Date: April 29 2025

File: 073124 - 45 Oak Street

URBAN DESIGN REVIEW PANEL REPORT - 45 OAK STREET

ÉÉP LOUISE-ARBOUR 45 OAK STREET, OTTAWA, ON

FOURTH LEVEL FLOOR PLAN
1:175

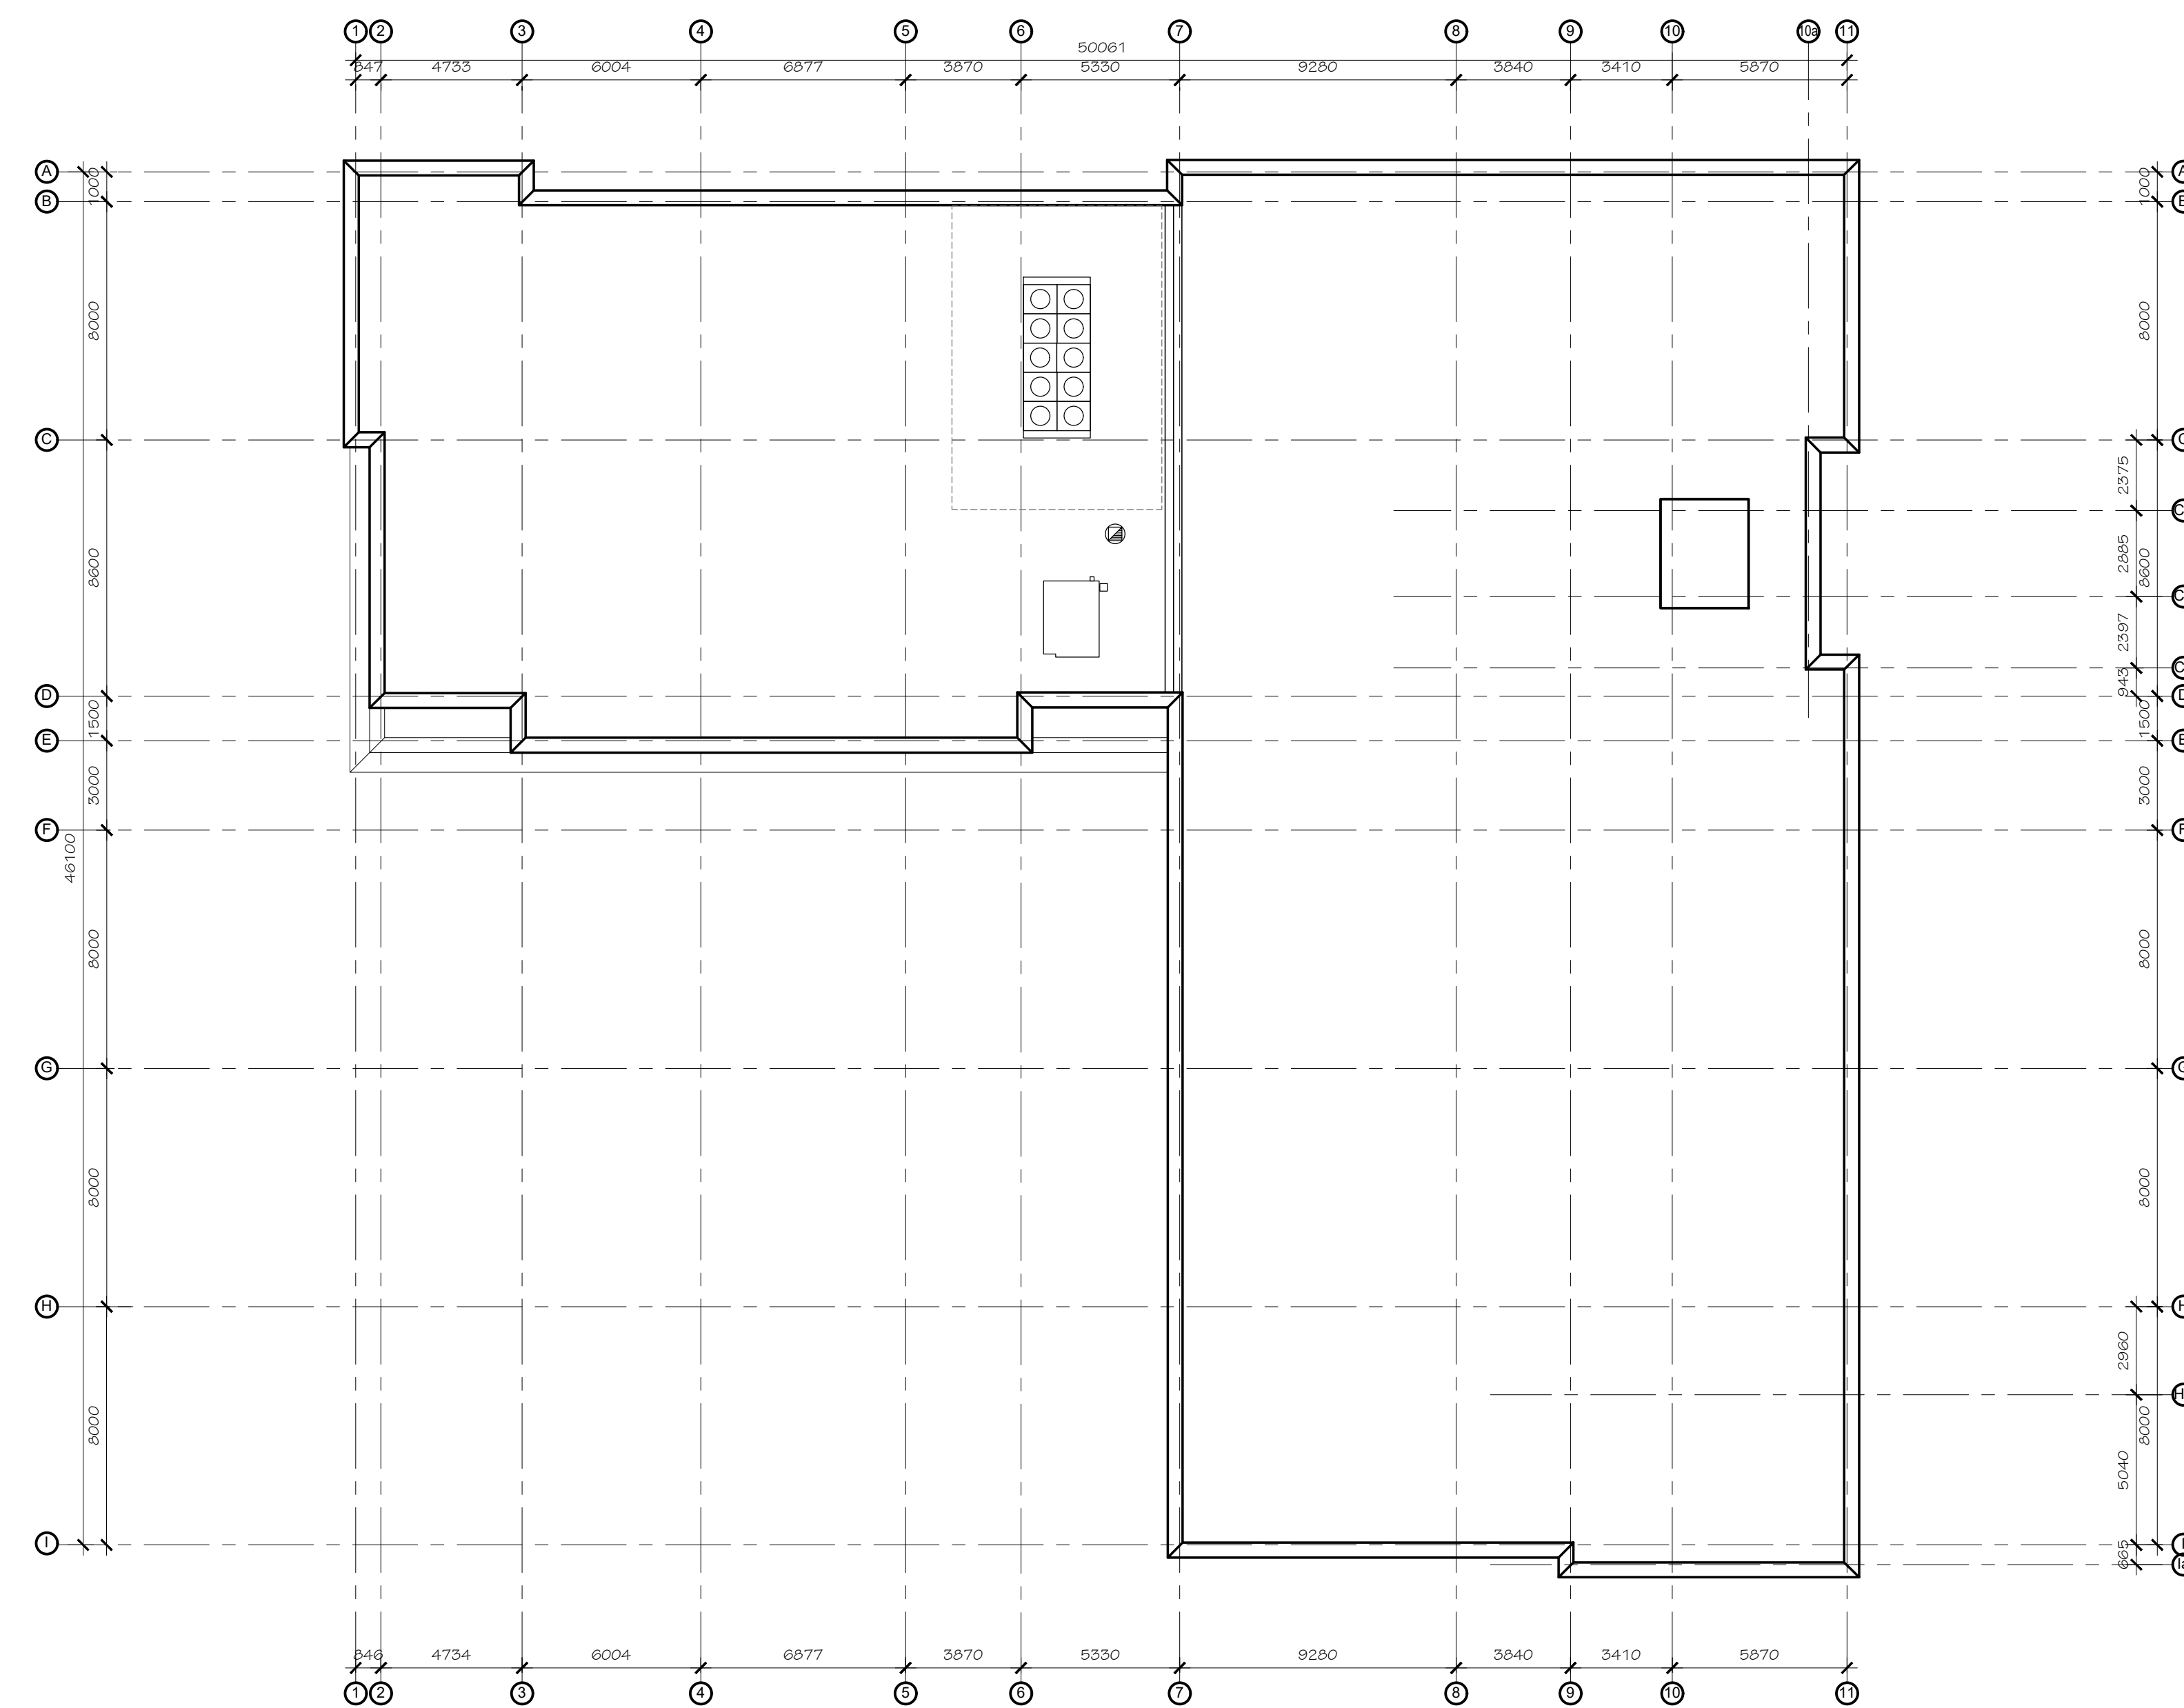
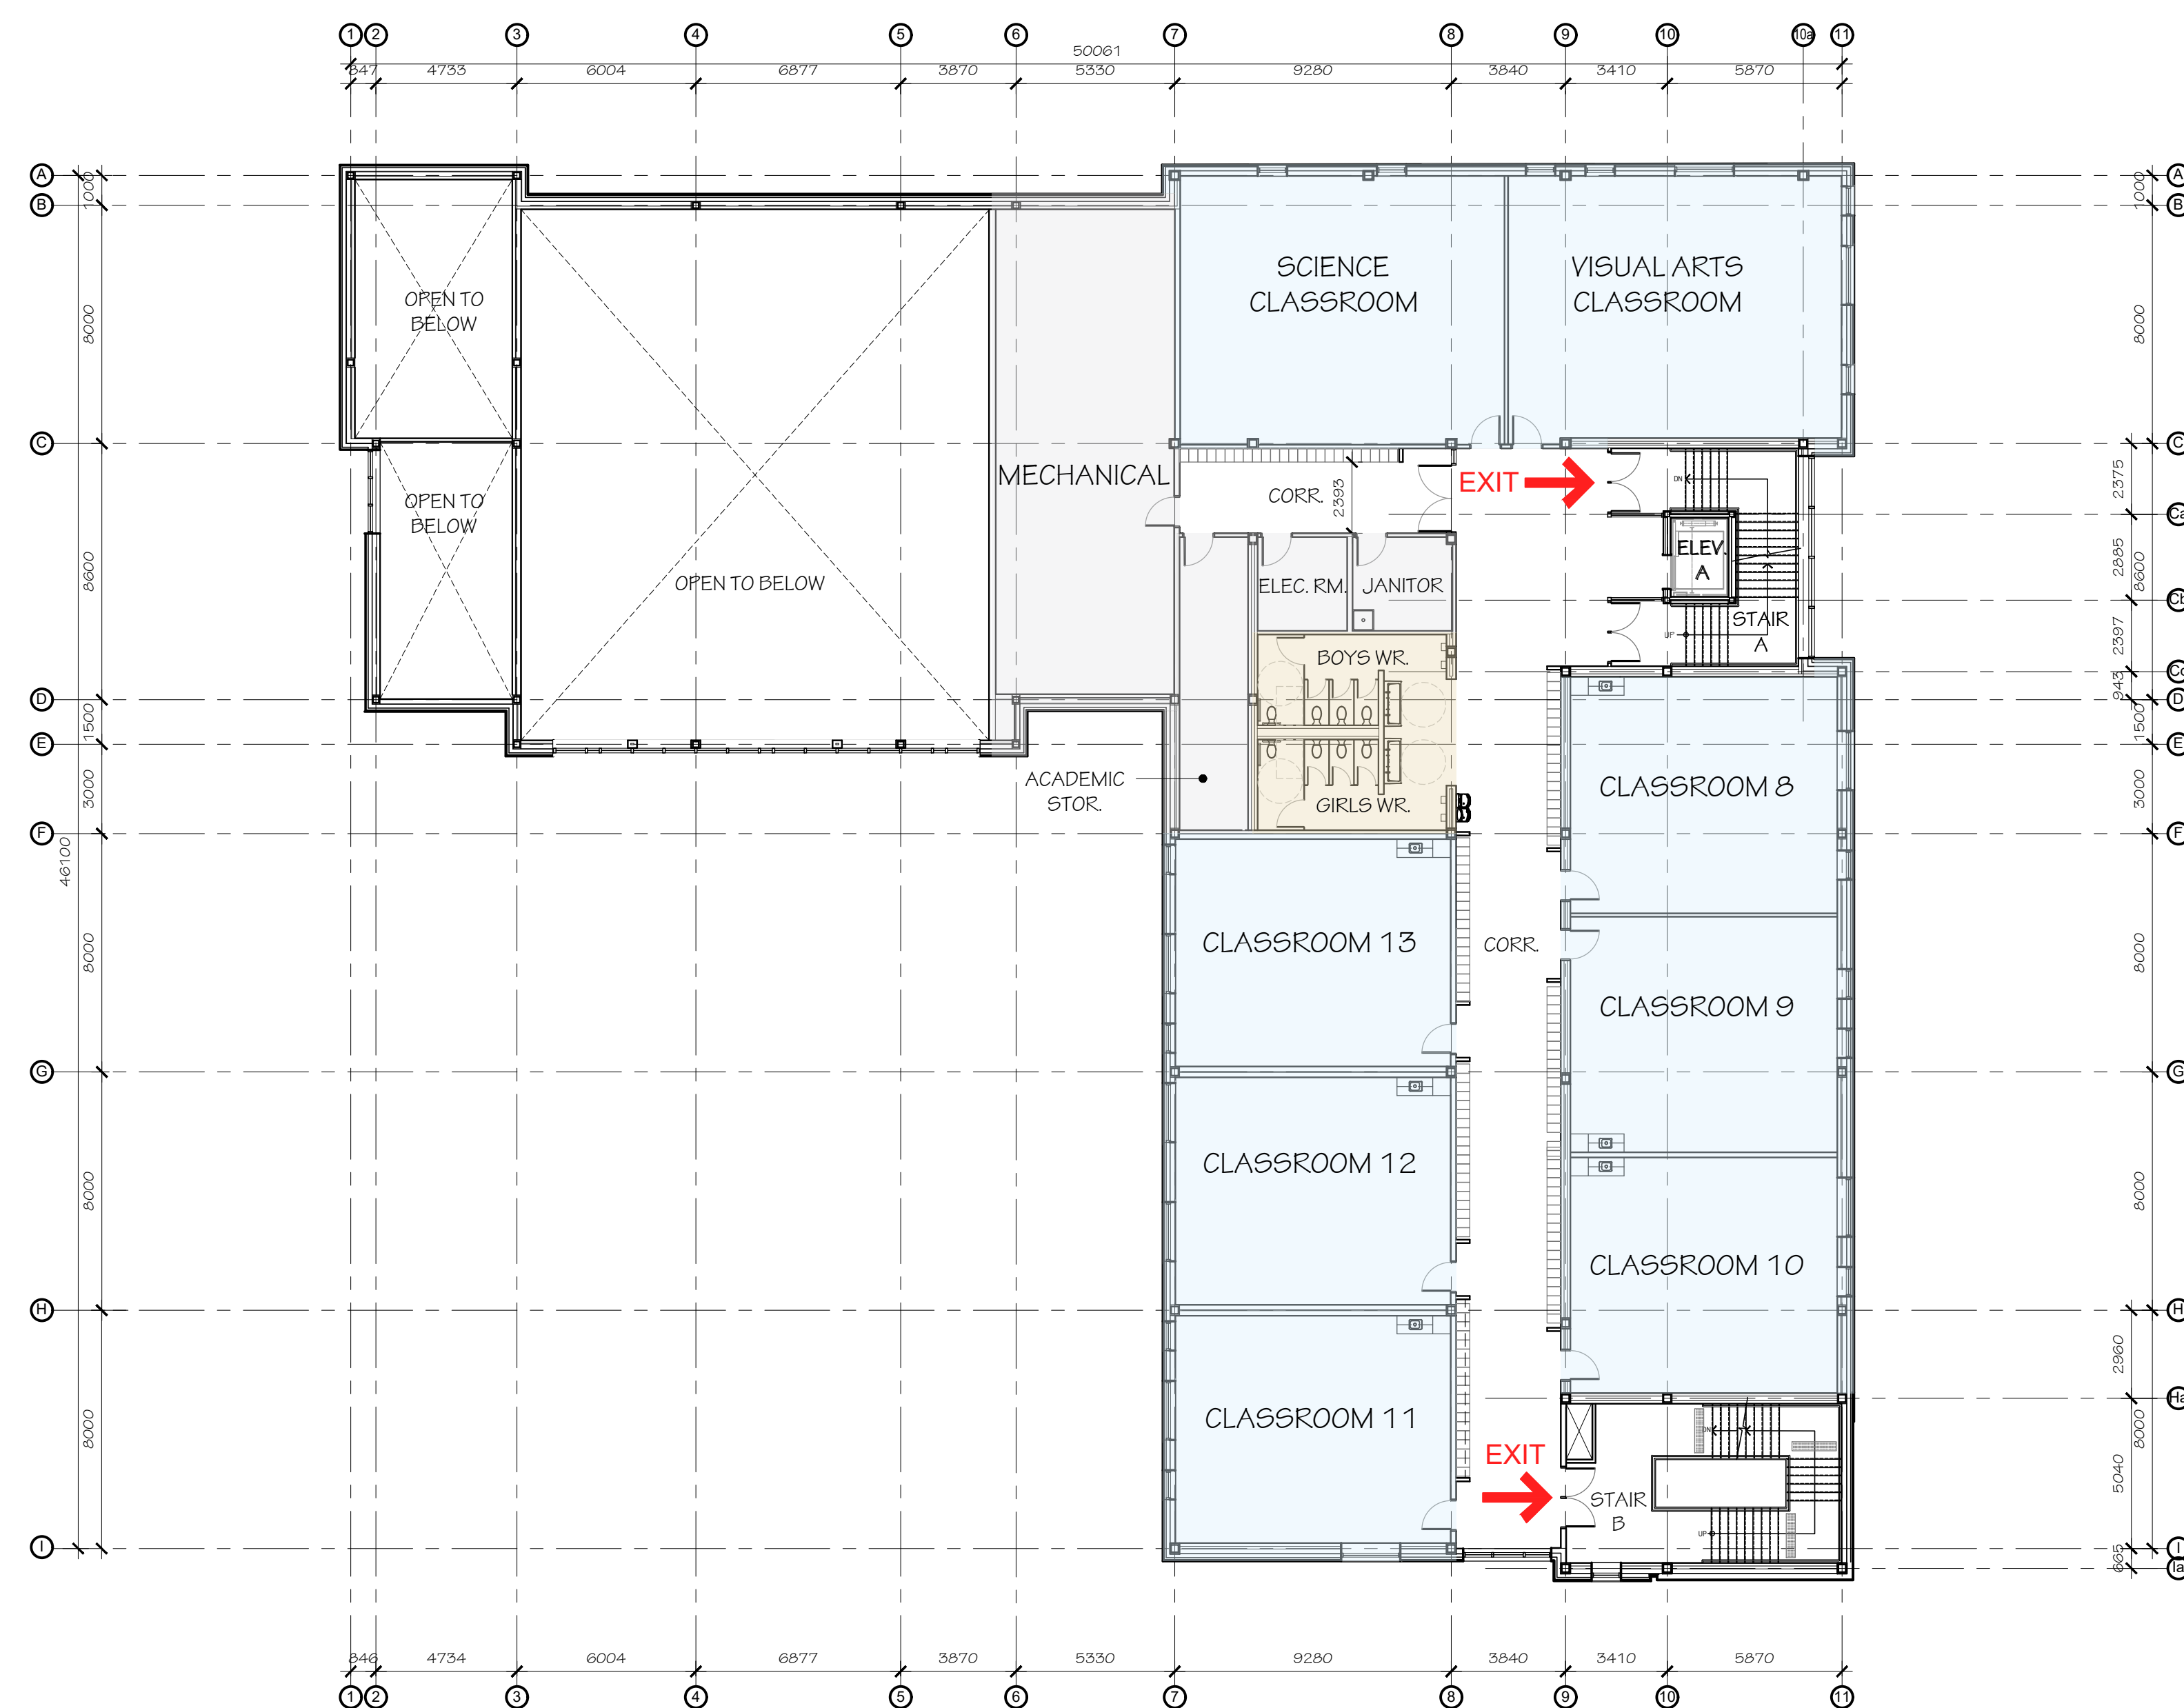
(20 of 25) The Panel appreciates the urban school typology and its potential to deliver a compact, multi-level education facility, but recommends refining the schools architectural expression to reflect its identify more clearly.

(21 of 25) The Panel suggests reconsidering the neutral architectural language of the school, proposing a more playful and colourful palette that distinguish it from adjacent residential towers.

The recommendation is appreciated and the team will review the architectural expression as the details of the design evolve through the Site Plan Control process.

The recommendation is appreciated and the team will review the architectural expression as the details of the design evolve through the Site Plan Control process.
